Re: G-Force Gymnastics
2500 Carlisle Blvd. NE
Traffic Impact Analysis-draft, HT#M09D033
Report dated September 2022
Engineer's Stamp -----
Via email jkruse@lee-eng.com

The subject Draft Site Traffic Analysis received on September 27, 2022, has been reviewed by the City of Albuquerque Planning Development Transportation Section. The City has the following comments:

Figure 1: Site Plan

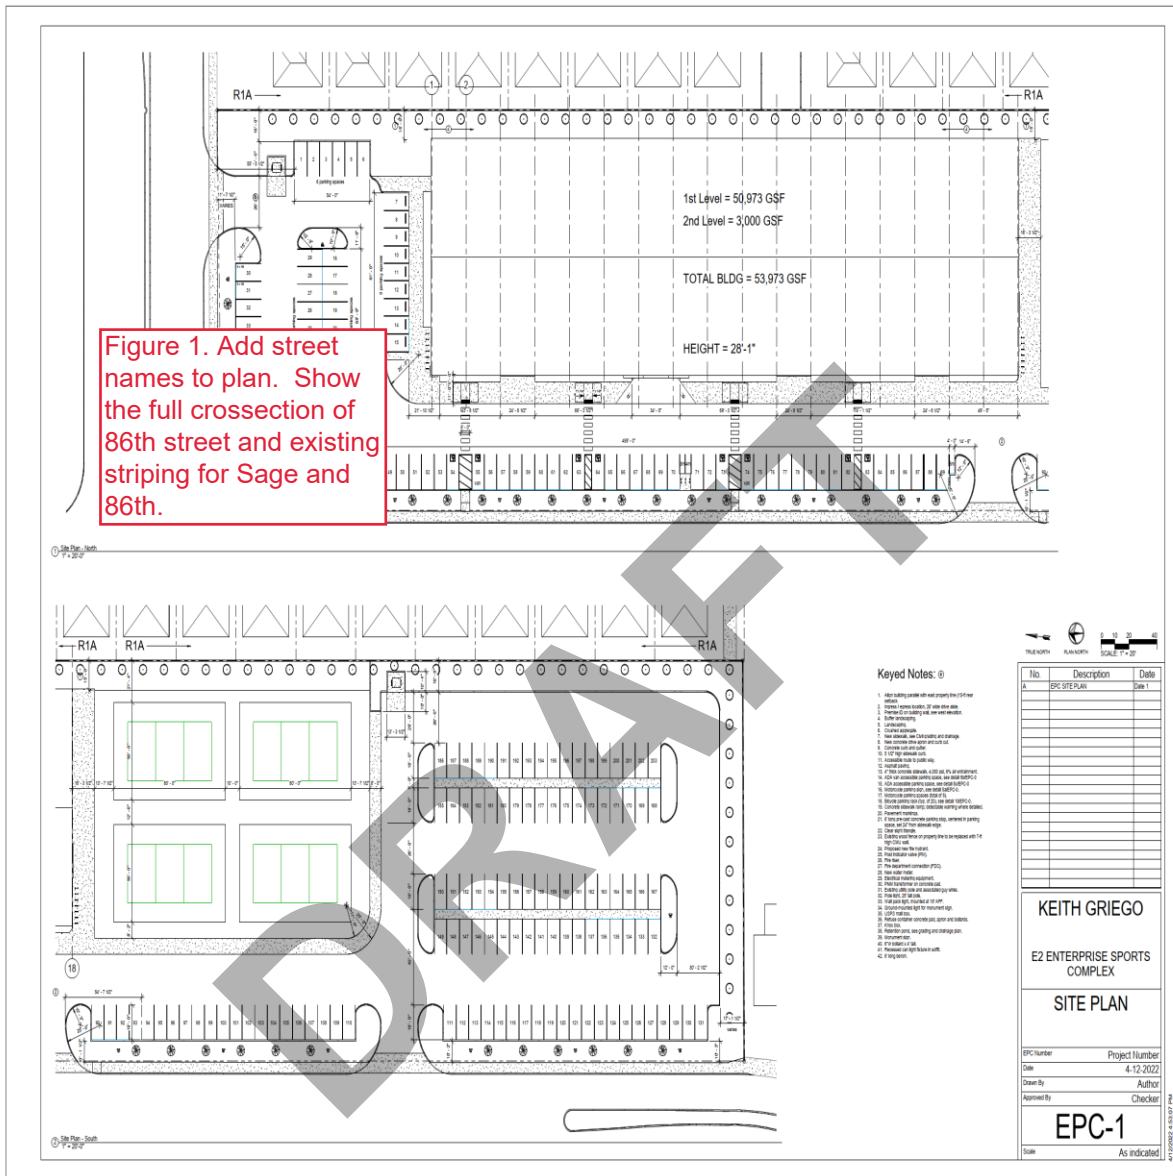
- Figure 1
 - Add street names and show the full crosssection of Sage Rd. and 86th St. with lane striping.
- Figure 4
 - Figure 4 appears twice. Remove the redundant figure
- Figure 5
 - Show the trips for driveways A, B and C. They may be zero but show the diagrams.
- Site Access Sight Distance
 - Refer to the COA DPM section 7-4(l)(5)(iii) Intersection Sight Distance
- Development Specific Recommendations
 - Build eastbound bicycle lane on Sage Rd. from 86th St. to the east property line.
